Ribble Valley Borough Council
Church Walk,
Clitheroe,
BB7 2RA

Phone: 0300 123 6780
Email: lhscustomerservice@lancashire.gov.uk
Your ref: 3/2015/0381
Our ref: LHS/CS/3/2015/0381
Date: 21st July 2015

Proposal:	Construction of an agricultural access track on land adjacent to Chadswell Hall to include the creation of a new access onto the public highway.
Location:	Chadswell Hall Chipping Road Chaigley Clitheroe BB7 3LT
Grid Ref:	367876 - 442199

Proposed agricultural access track at Chadswell Hall  
 Chipping Road, Chalgley, Clitheroe, BB7 3LT ~

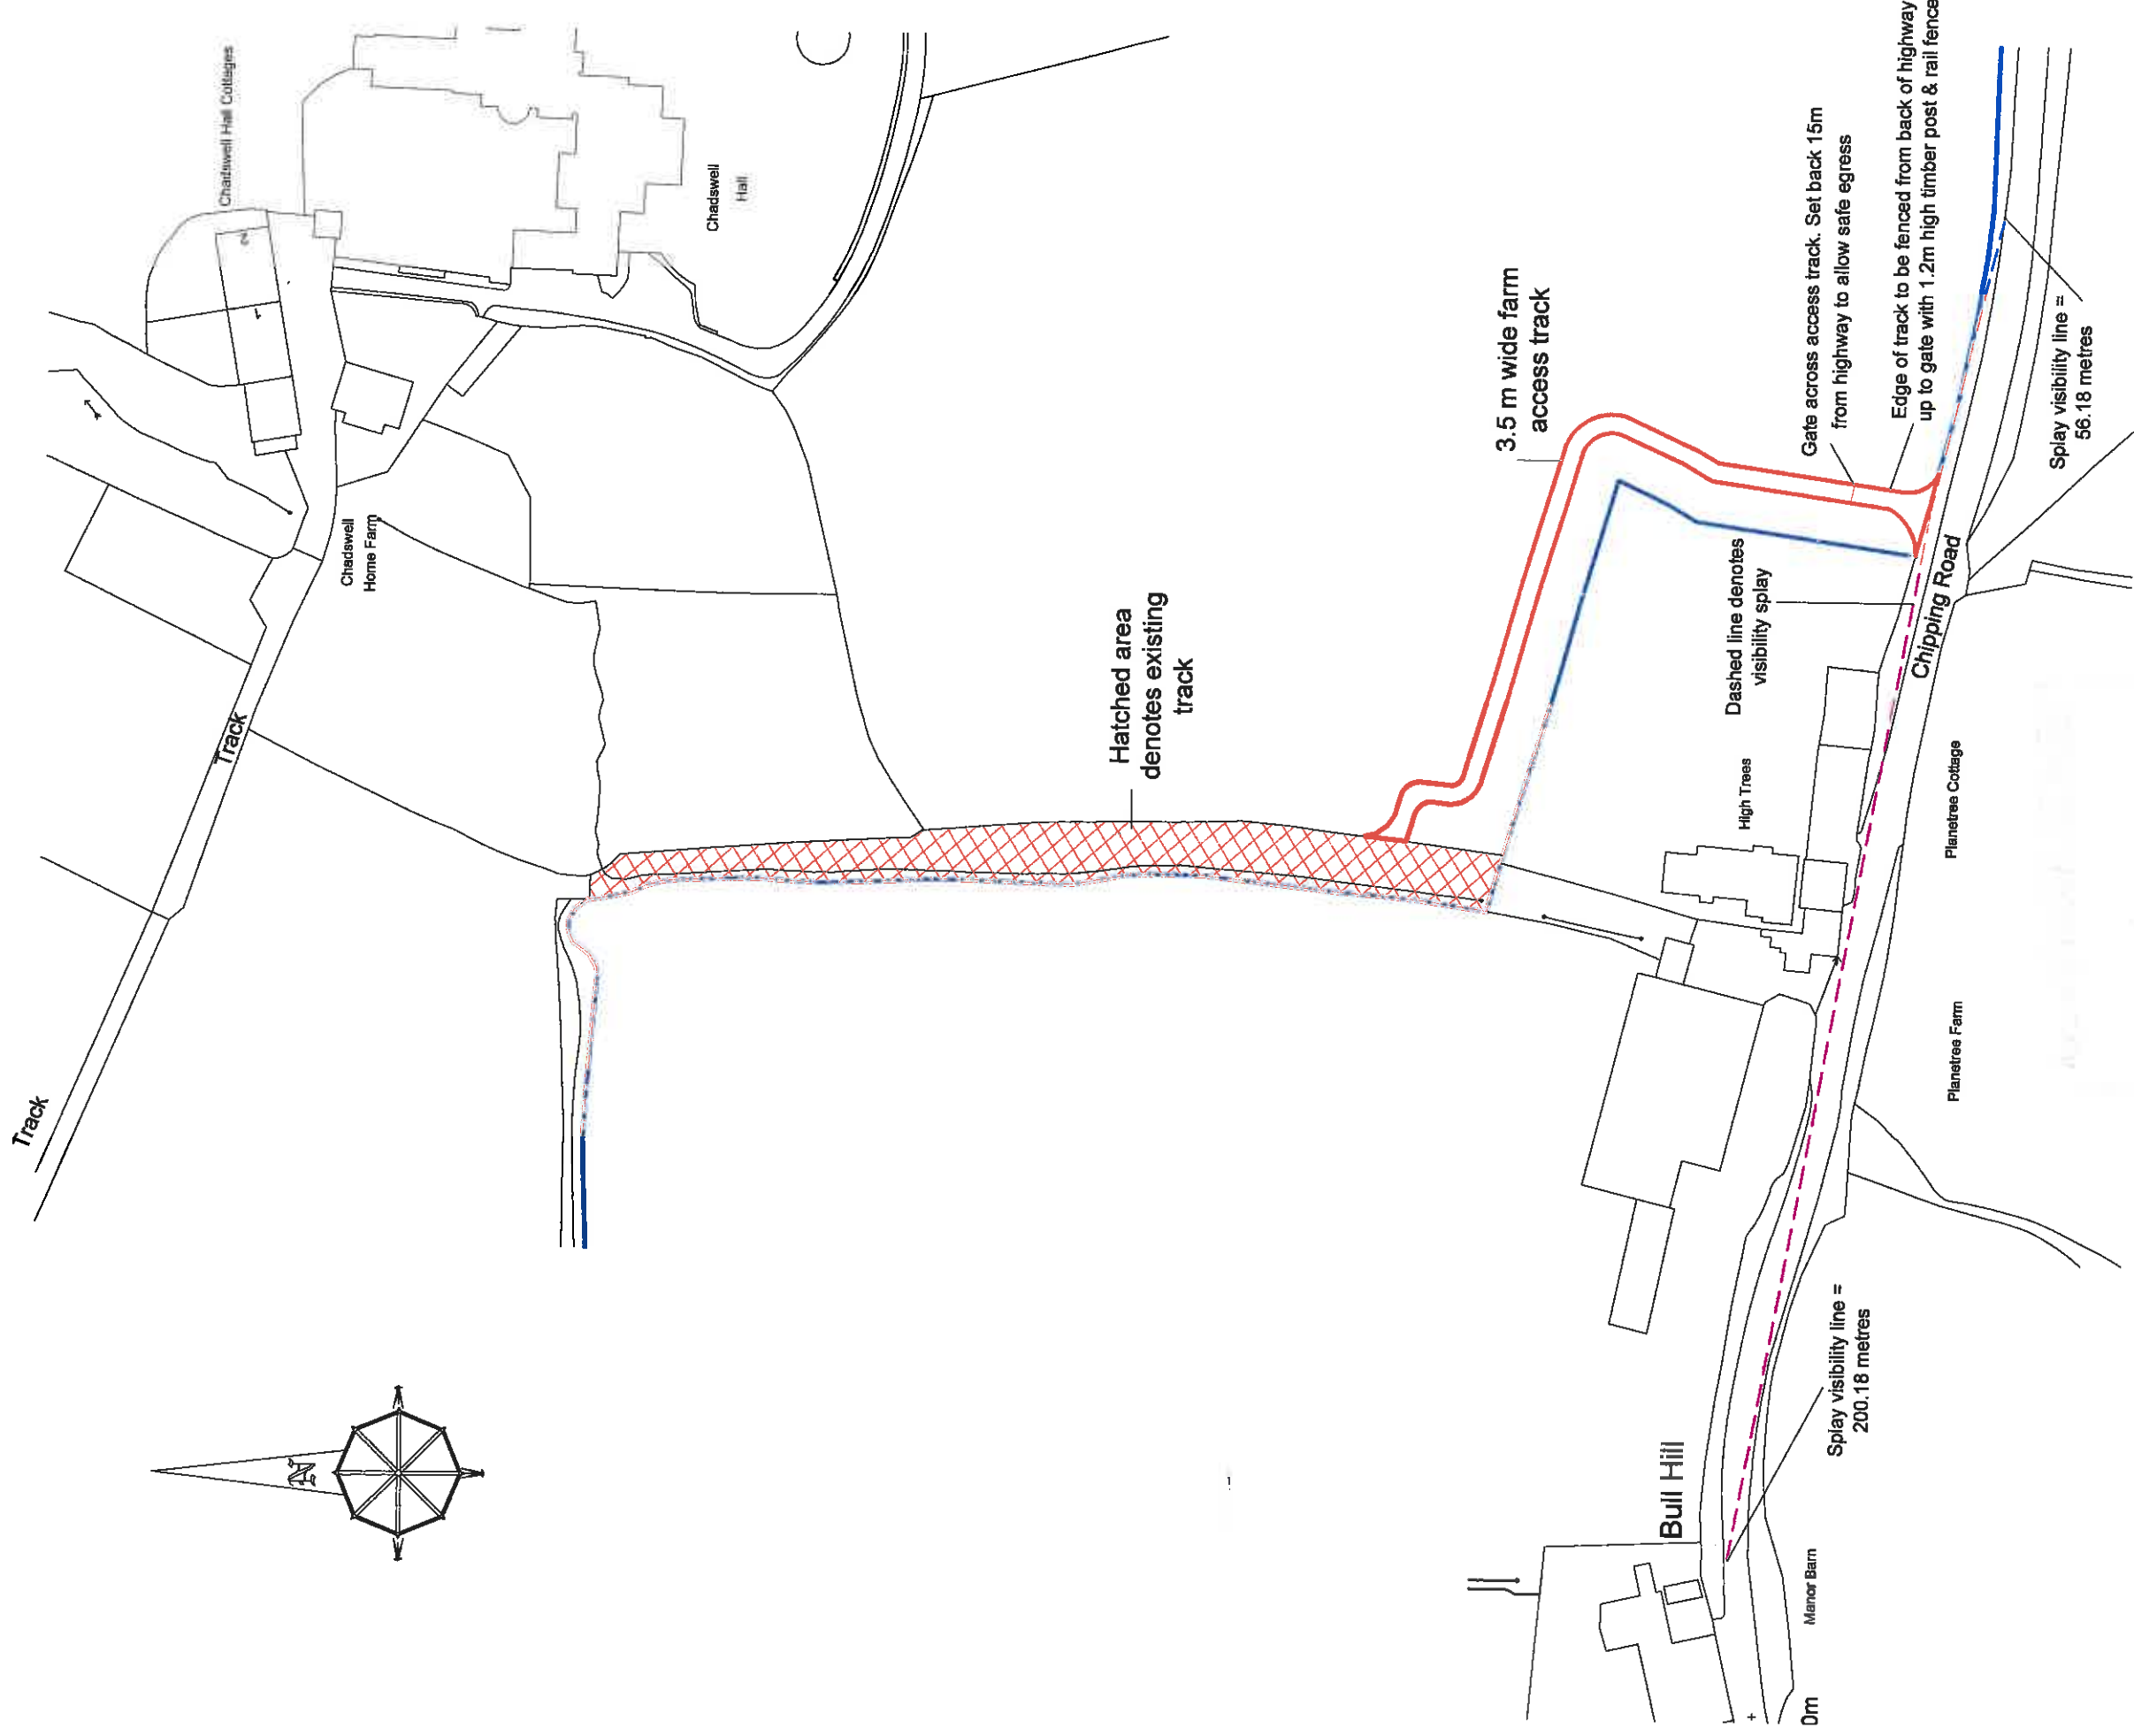
The sight lines of 2.4 x 114m to be provided in both directions from the centre of the new site access onto Chipping Lane. The site line requirement is, based on the basic formula (absolute minimum) for calculating Stopping Sight Distances (SSD) in table 10.1 from Manual for Streets 2, the addition of 2.4m an estimated 85th percentile speed of 50 mph. The "Y" distance can be 750mm from the near side carriageway channel line.

The applicant should provide accurate details of the required sight line requirement, before determining the application, ensuring the entire sight line requirement is fully over land within the applicants control and/or over the adopted highway and to fully show all works which would be required to provide the sight lines. The sight line recommendations will require walls, fences, trees, hedges, shrubs, ground growth, structures etc. to have a maximum height of 1.0m above the height at the centre line of the adjacent carriageway.

From observations on site and the information provided on the applicant's site location plan the sight line requirement is fully achievable over the applicants land and the existing adopted highway. The main issue is removal of the hedge, relocation of the fence and possible impact on the trees to the west of the site access for approximately 70 to 80m east of the new access.

4. No part of the construction shall begin until the visibility splays measuring 2.4 metres by 114 metres in both directions to be provided, measured along the centre line of the proposed new road from the continuation of the nearer edge of the existing carriageway of Chipping Road, to the satisfaction of the Local Planning Authority. The land within these splays shall be maintained thereafter, free from obstructions such as walls, fences, trees, hedges, shrubs, ground
